**Our Ref: R/224/12/
Your Ref:**

Application for Planning Permission for Works or Extension to a Dwelling

Development Ramped access leading from front drive to new single storey side extension.

Location 17 Barwick Close Rustington

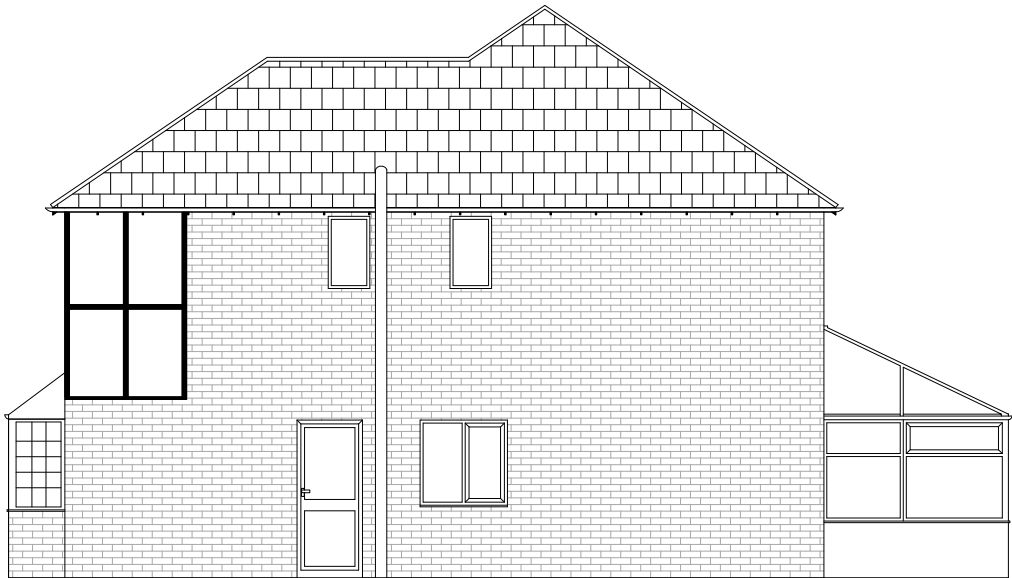
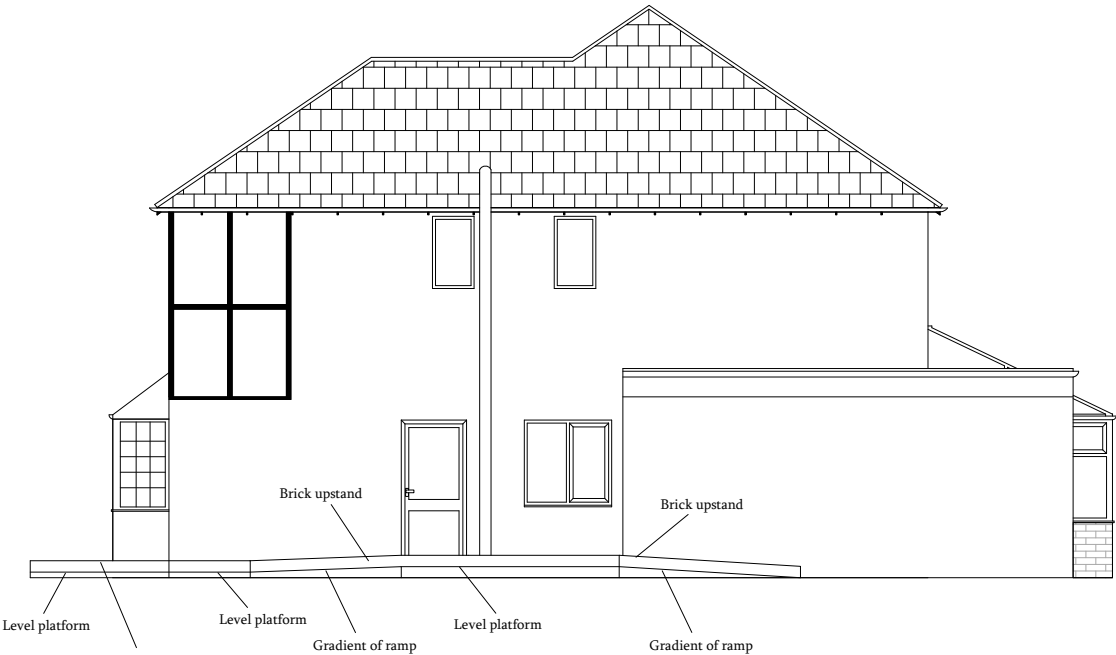
Please provide elevations showing the proposed ramp. ✓ 10/12

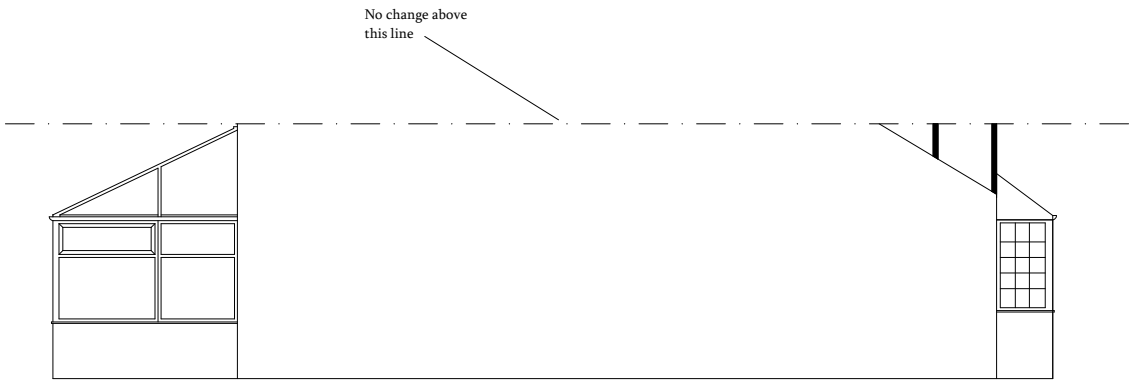
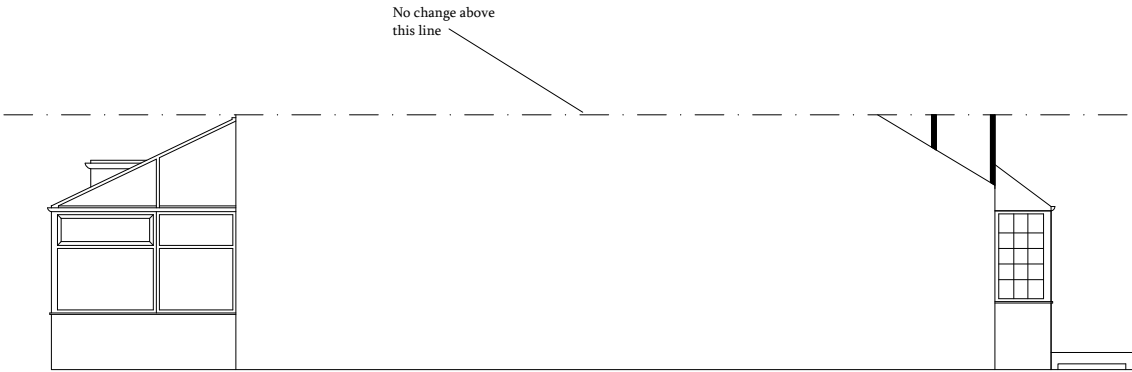
Please provide the existing and proposed North elevation. ✓ 10/12
